Our ref: L.A11230.003.StPhilipsCC-RTS.docx

25 October 2022

RE: RESPONSE TO SUBMISSION - ST PHILIP'S CHRISTIAN COLLEGE, CESSNOCK SSDA

Table 1.1 Response to Submission

Proposed Site Plan - Overall

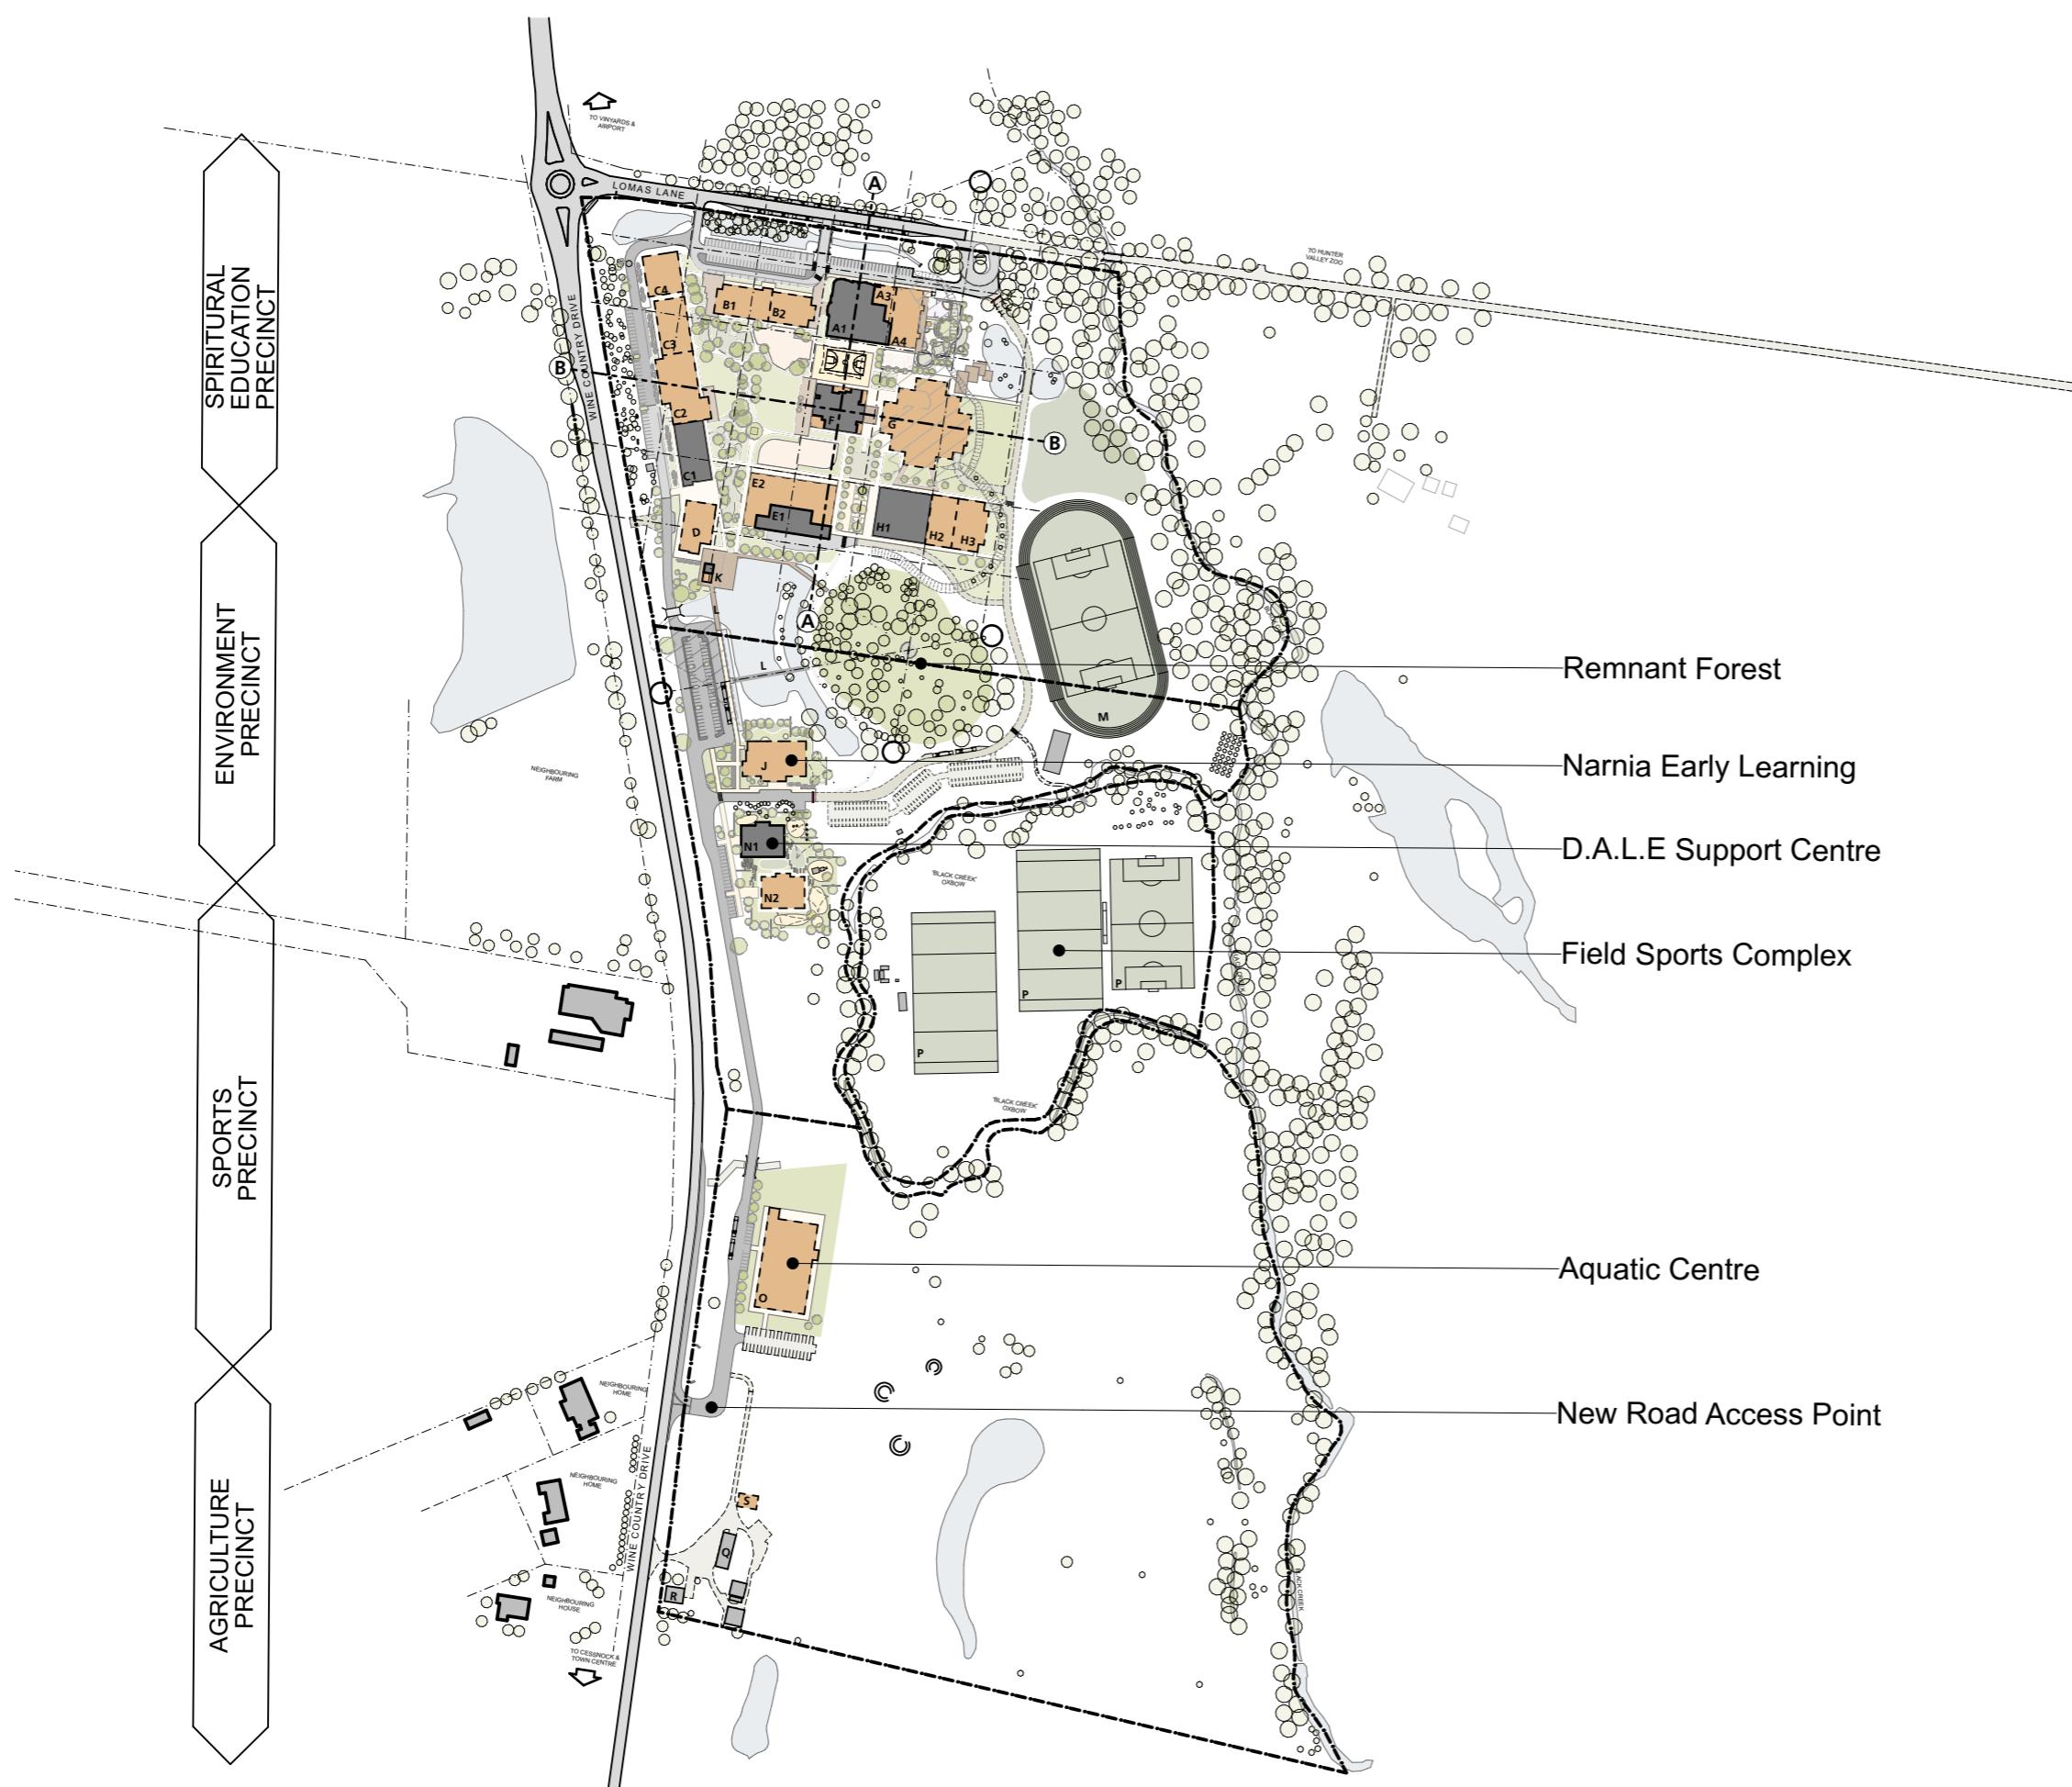
• <i>the FIA has not undertaken a detailed assessment of the flood planning levels for each of the proposed buildings to ensure that floor levels are above the 1% Annual Exceedance Probability (AEP) flood extent. Further assessment of the proposed finished floor levels across each individual building and the associated flood impacts and risks is required to demonstrate that the buildings are not impacted by the 1% AEP affecting the site.</i>	The proposed finished floor levels (FFLs) are higher than the 1% AEP peak flood level and include a minimum freeboard of 0.5m above the peak flood levels. A table listing the FFLs of the proposed buildings and the peak flood levels is included in Table 1.2.

<i>5. BCD recommends that the proponent review and amend the current detailed flood emergency response plan (FERP). It is suggested that any approvals for further development of the site be contingent on a review of the adequacy of an amended detailed FERP.</i>	BMT has prepared an updated Flood Emergency Response Plan (FERP) for the Site which assessed feasible evacuation routes and recommended early evacuation as the primary flood emergency response strategy. Detailed arrangements for the full evacuation of the Site are included in the updated FERP.
<i>6. BCD recommends that additional colour graduations, above 60.25m are added to Figures B8 and C8 in the flood impact assessment.</i>	Attached to this letter report are the corresponding flood maps with revised colour graduations.
<i>7. BCD recommends that the estimated climate change impact on flood levels, for the design life of the development, be included in the 1% AEP flood level. The minimum floor level should be based on the 1% AEP flood level (including climate change) plus 500mm freeboard.</i>	The FFLs of the proposed buildings have a minimum freeboard of 0.5m above the 1% AEP peak flood levels. A table listing the FFLs of the proposed buildings and the peak flood levels is included in Table 1.2. Whilst BCD's recommendation is acknowledged, the nominated Flood Planning Levels (FPLs) are in accordance with Council's DCP requirements (i.e, the 1% AEP peak flood level plus a minimum freeboard of 0.5m). Section 5.3 of the 2021 FIA presented an assessment of impact of climate change on the 1% AEP peak flood levels which demonstrated that climate change will result in a maximum flood level increase of 0.3m within the site. This demonstrates that the nominated FFLs would remain flood-free under climate change scenario with a minimum freeboard of 0.2m. Notwithstanding, all FFLs of the proposed buildings have freeboard beyond the minimum 0.5m required by Council's DCP as shown in Table 1.2.
